PROJECT NO. PR-2019-002765

Application No. SD-2020-00218 / VA-2021-00010

**DESCRIPTION:** Plat and Infrastructure List for Subdivision Plat fo Lots 8 and 9 of Coors Pavilion has been updated

**Re: Proposed Lots 8-A, 8-B, 8-C, 9-A, 9-B and 9-C, Coors Pavilion**

**Detail of Easements 1, 4, 8, 9, 10, 13, 16, 19, 21, and 22**

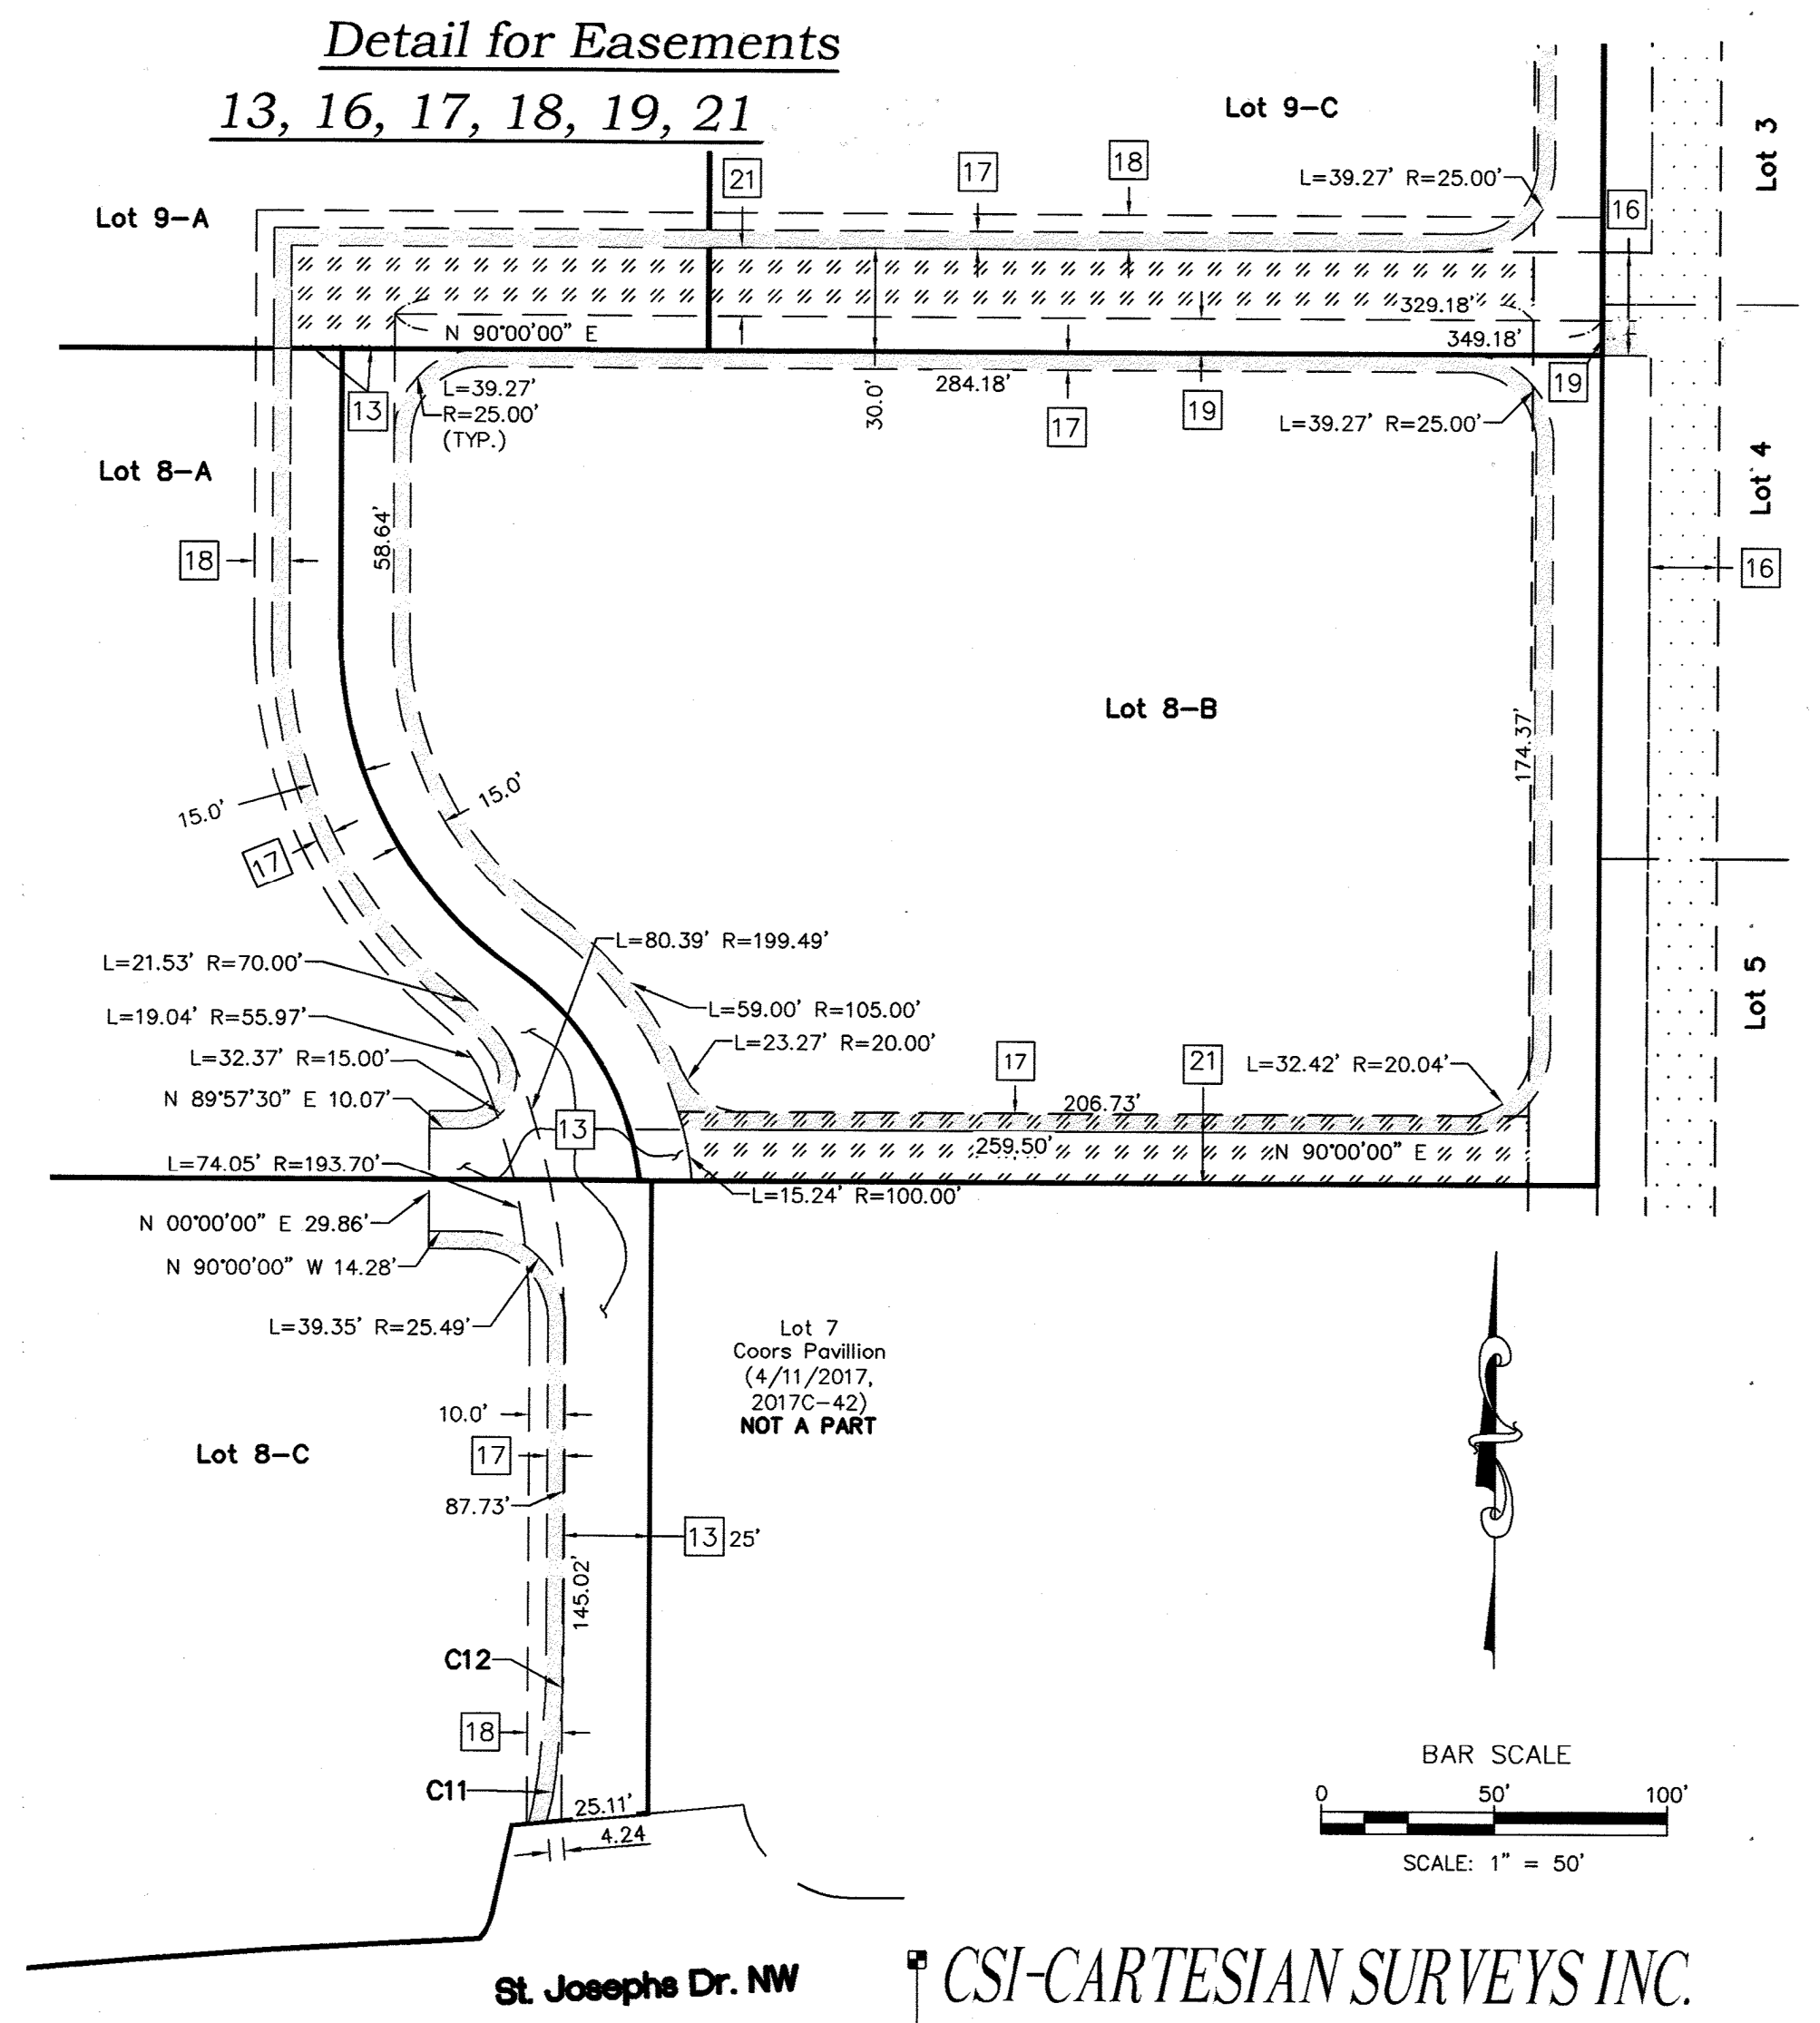
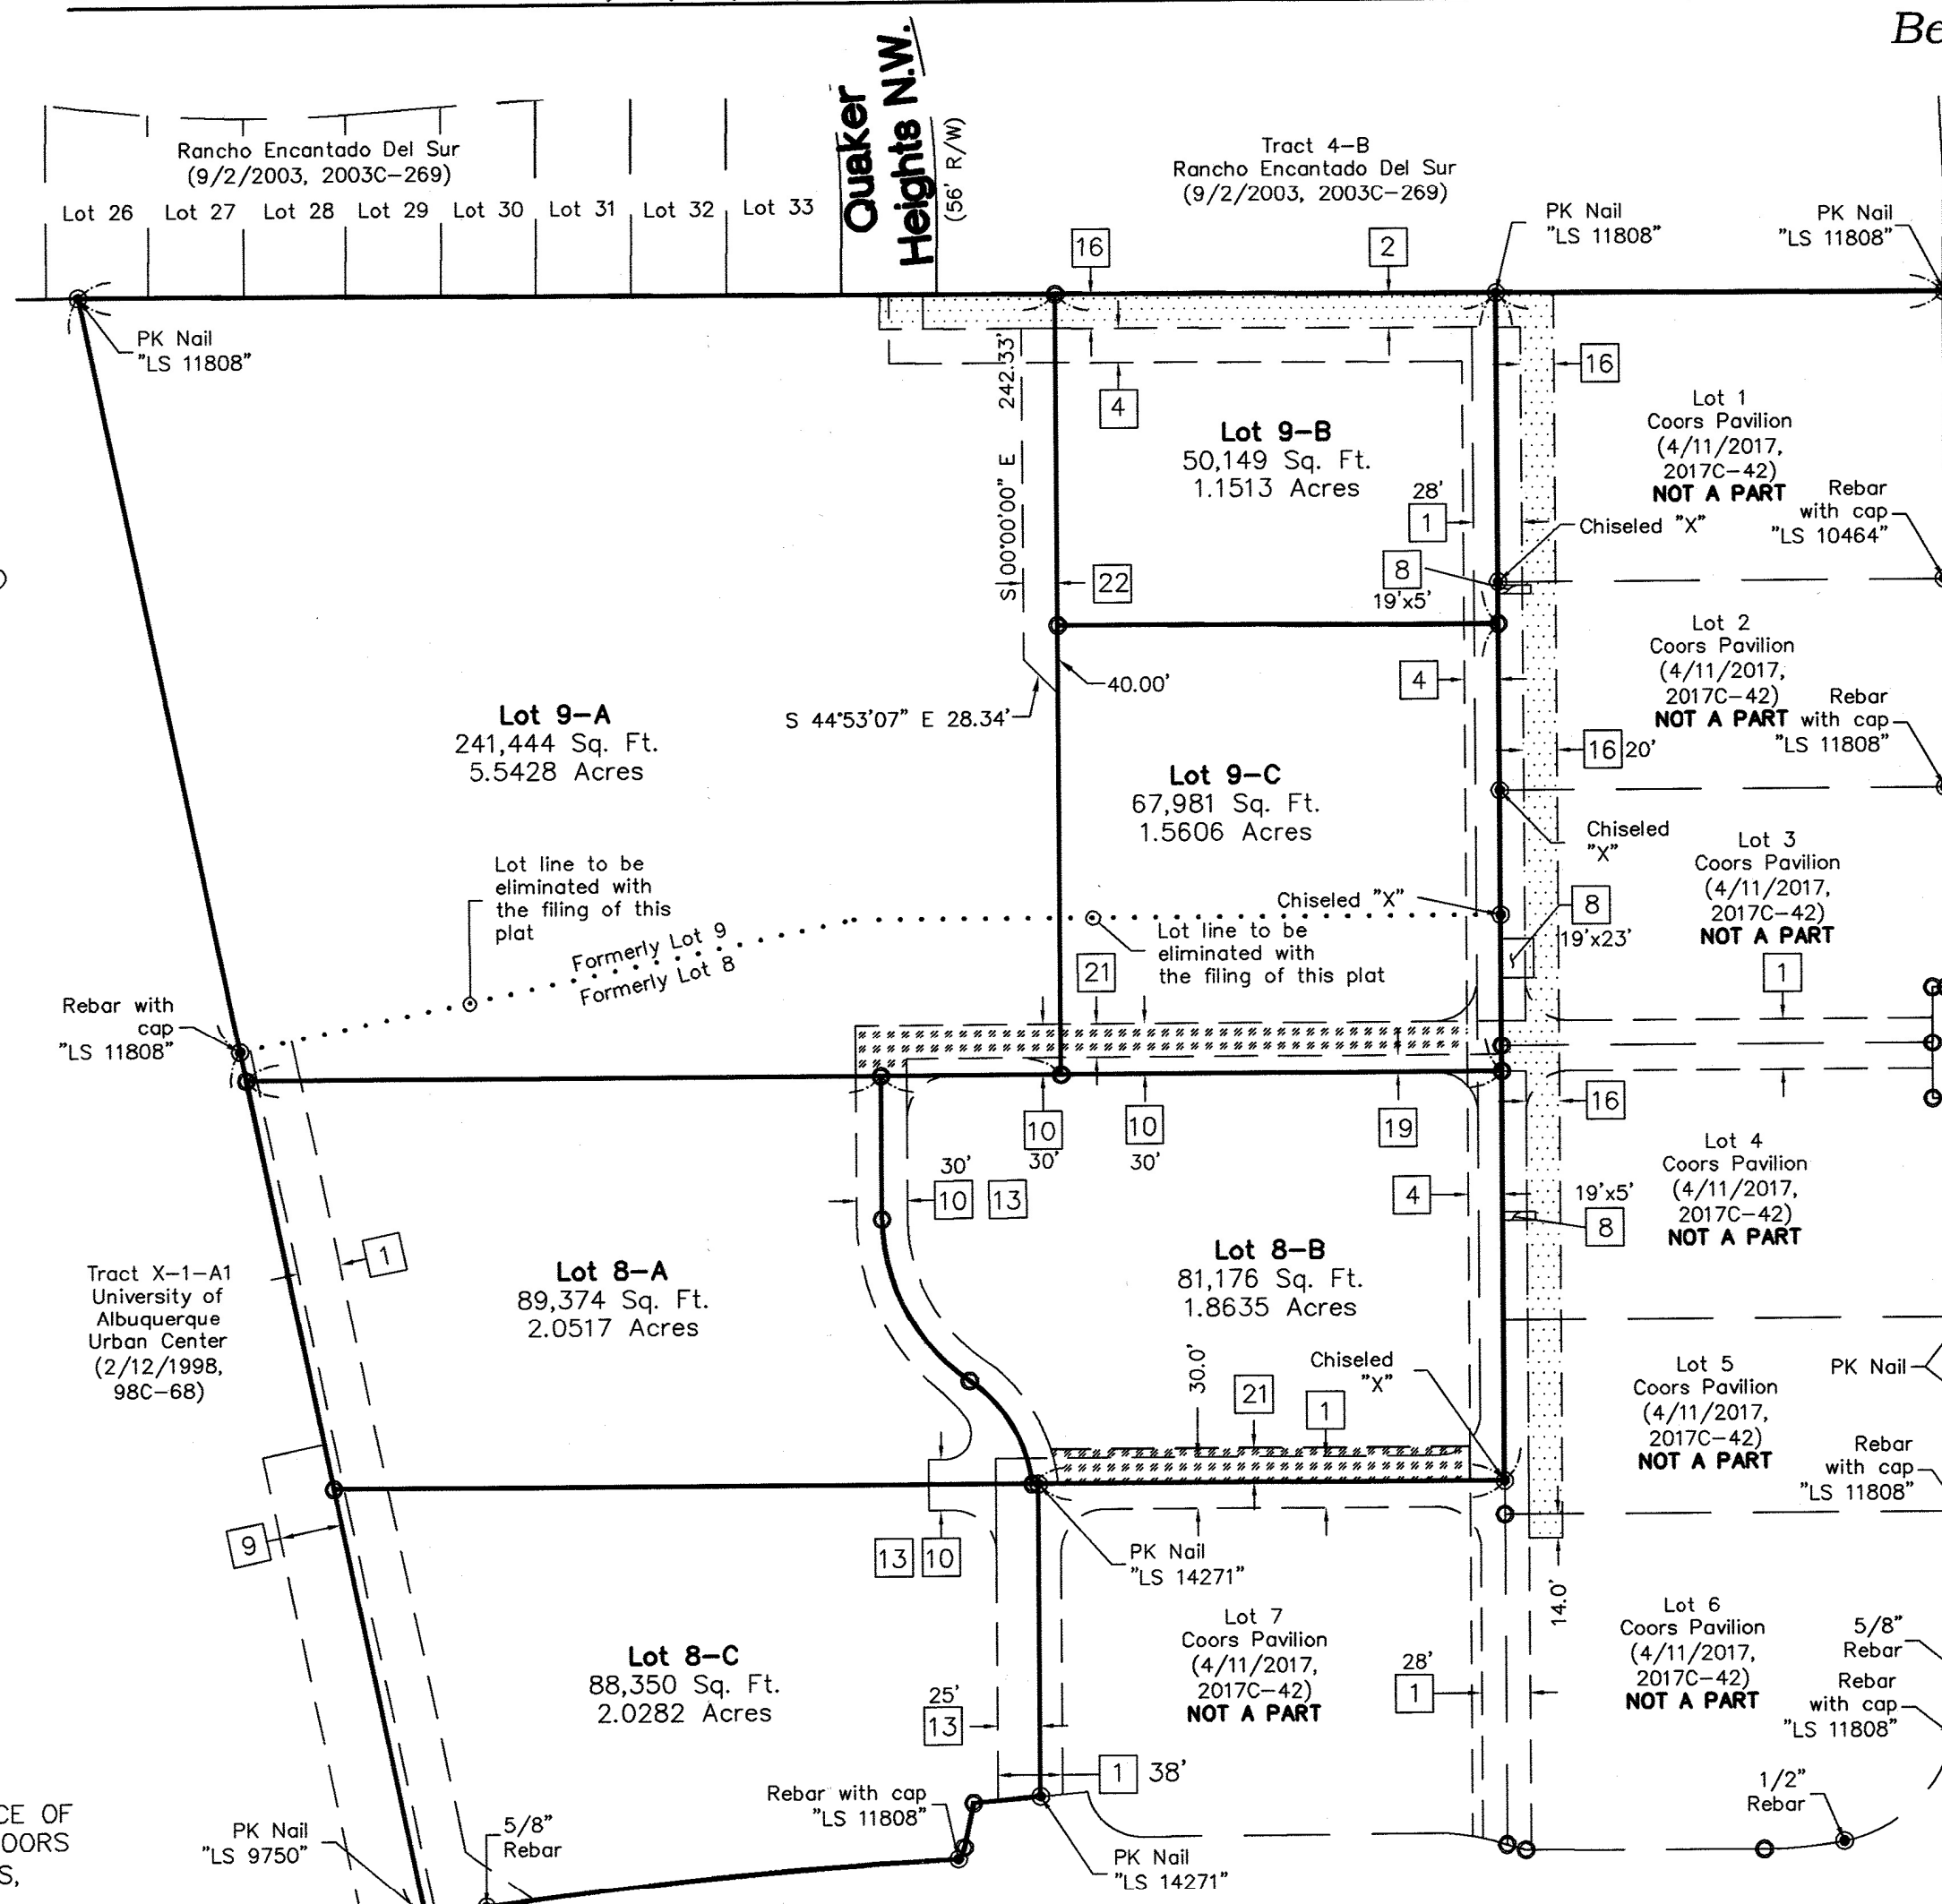
- j. If Easement #13 is to be for a public waterline and sanitary sewer, there will need to be additional offsite public sanitary sewer for this easement to connect to the public sanitary sewer that will be granted for the converted public sanitary sewer. There is a gap between the east property line of proposed Lot 9-C and the public sanitary sewer easement associated with the converted public sanitary sewer.
  - i. Response to comments referred to Detail B on Sheet 2. This detail shows easement #13 as the same width of easement #16. The dimension shows easement #13 having a width of 30', whereas the keyed note for easement #16 indicates a width of 20'. Please confirm.

Labels have been added to the detail on Sheet 2, which confirms the easement 16 matches the easement 13 width of 30 foot as labeled, where it serves to bridge easement 16 to 13. The easement not indicating easement 16 is 20 feet has been removed to avoid this confusion.
